Appeal Decision

Appeal Ref: APP/R5510/D/21/3280879

105 Great Central Avenue, Ruislip HA4 6TU

- The appeal is made under section 78 of the Town and Country Planning Act 1990 against a refusal to grant, planning permission.
 - The appeal is made by Mr Tossel against the decision of The London Borough of Hillingdon.
 - The application Ref 55304/APP/2021/1822, dated 4 May 2021, was refused by notice dated 30 June 2021.
 - The development proposed is Single Storey Wrap Around Extension.
-

PROPOSED SIDE ELEVATION

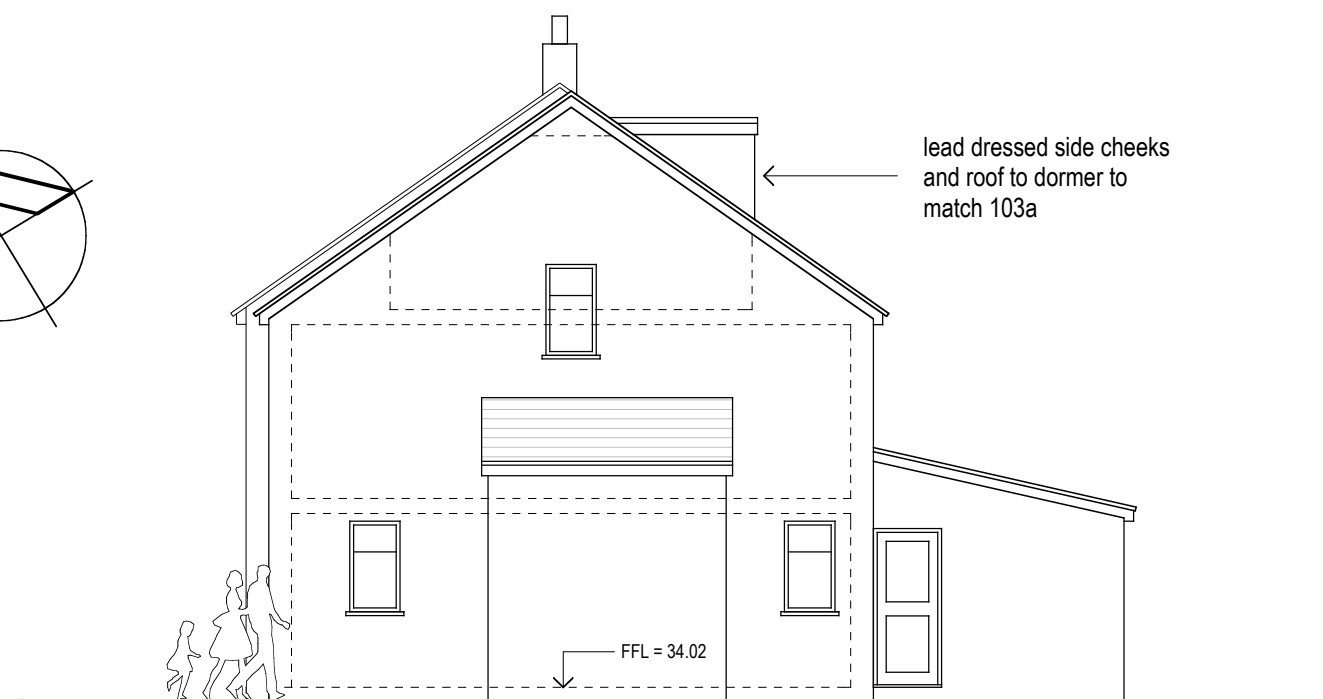
5. The side extension would appear as an uncharacteristically wide extension when viewed from the front elevation, in relation to the host dwelling. Its excessive width would appear out of proportion with the host dwelling. Even with the use of matching materials and fenestration detail, it would not harmonise with the host dwelling or appear as a subordinate addition. Thus, it would appear detrimentally harmful to the host dwelling and to the character and appearance of the local area to which it is visually experienced.
